Application No: AB/49/22/HH
Site Address: 31 Tarrant Wharf Arundel BN18 9NY
Description of works: Erection of single storey rear extension including the installation 2 x rear balconies and side rooflight and alterations to fenestration. This application may affect the character and appearance of the Arundel Conservation Area.

Thank you for your internet representation made on 25th May 2022 which has been recorded as an objection with the comments as follows:

DRAWING TITLE
 PROPOSED FLOOR PLANS,
 SECTION AND ELEVATIONS

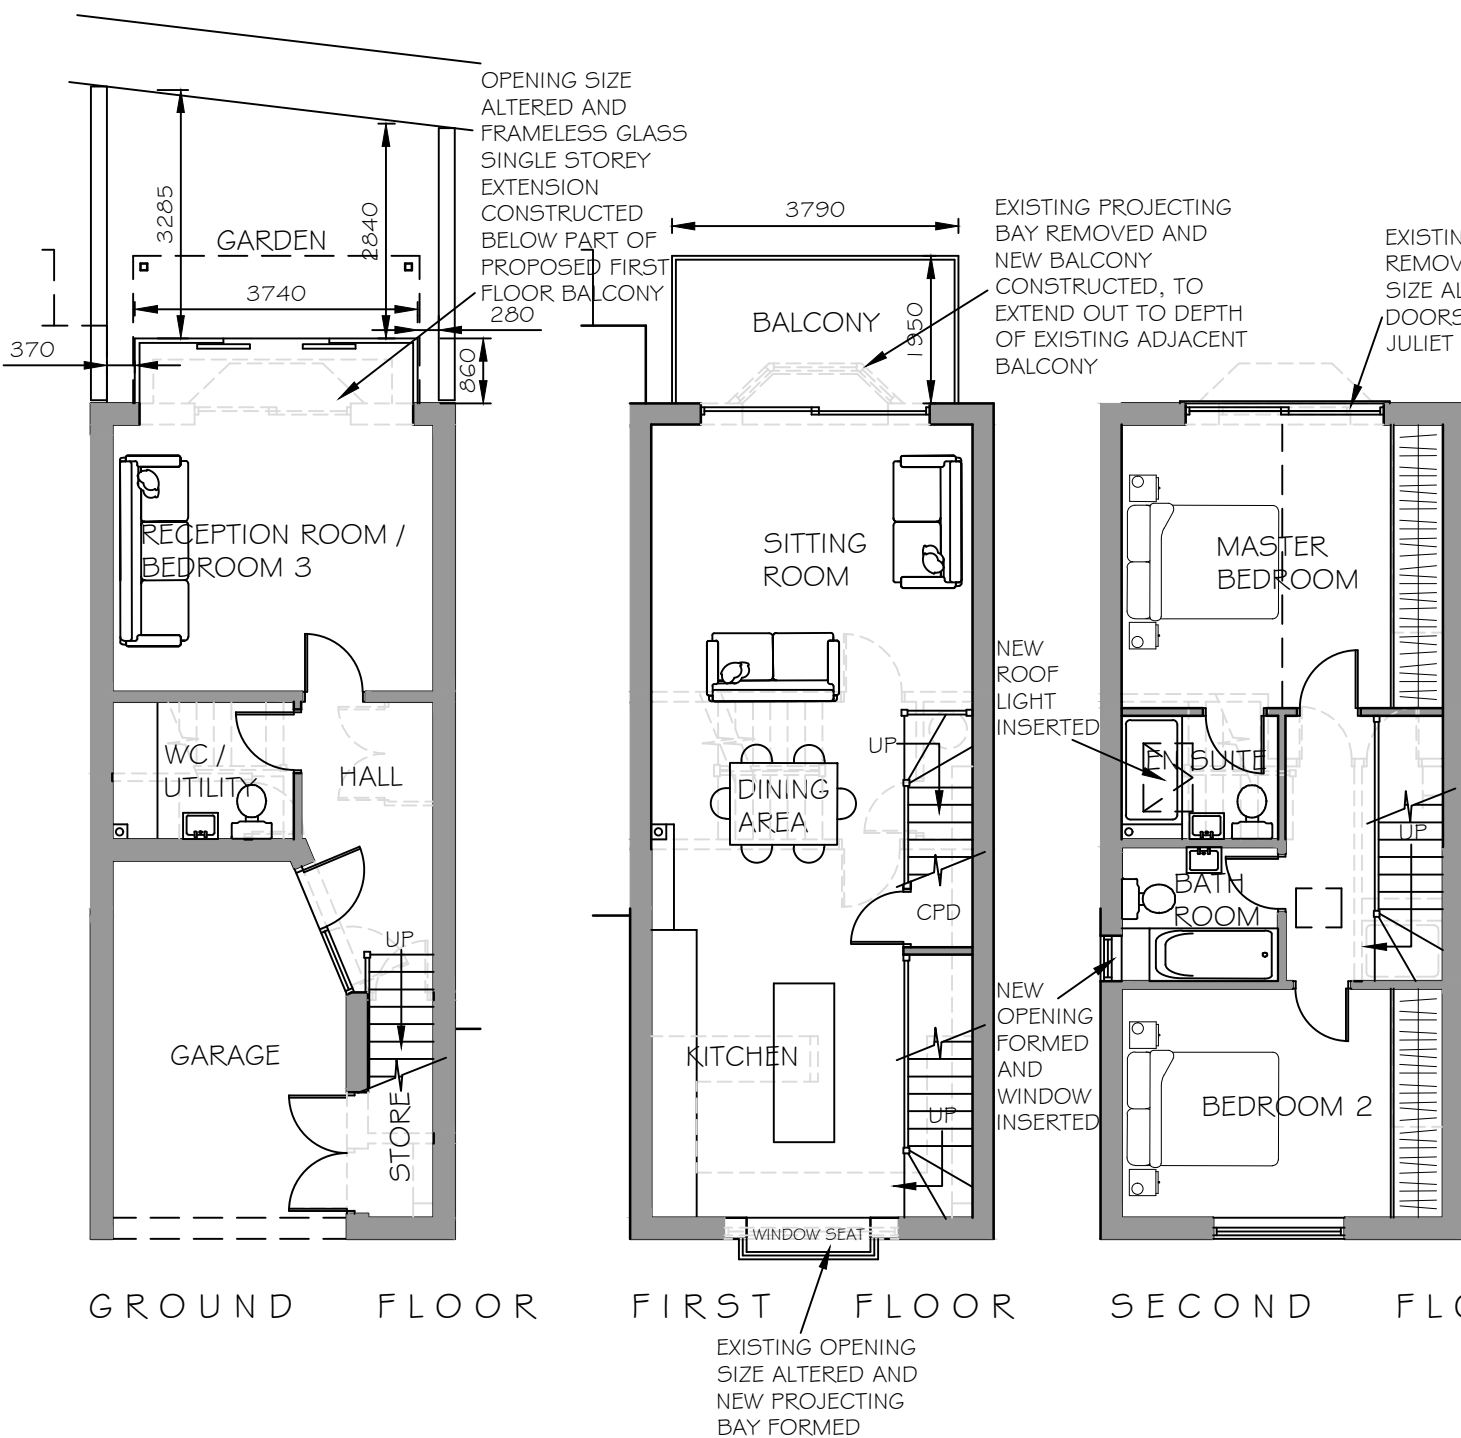
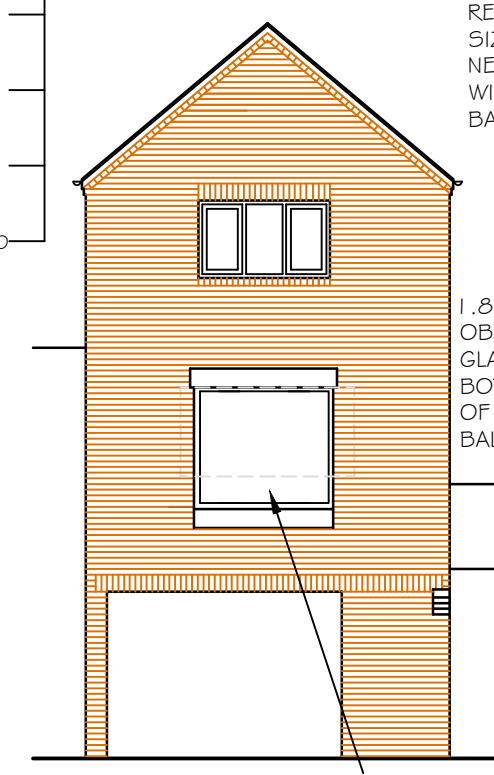
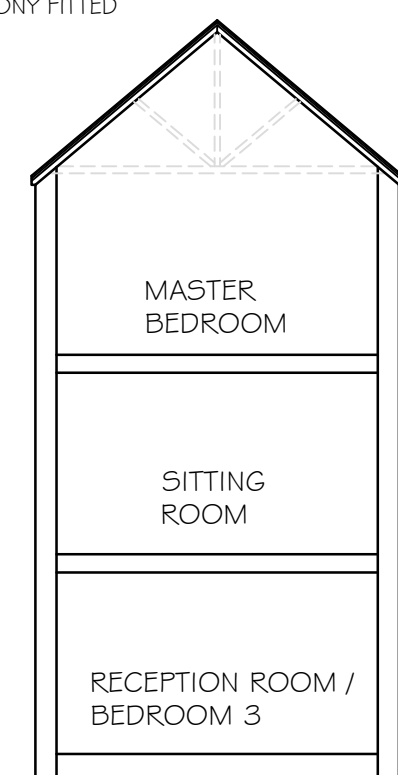
The proposed works would seriously impact on the consistent appearance of the Tarrant Wharf development, and impinge on the views of the river from the rear of the adjoining properties.

I am also extremely concerned of the likely impact on the SSP river defence wall, as the existing properties are all piled, and any rear extension would likely have to be of similar construction and in close proximity to the SSP wall.
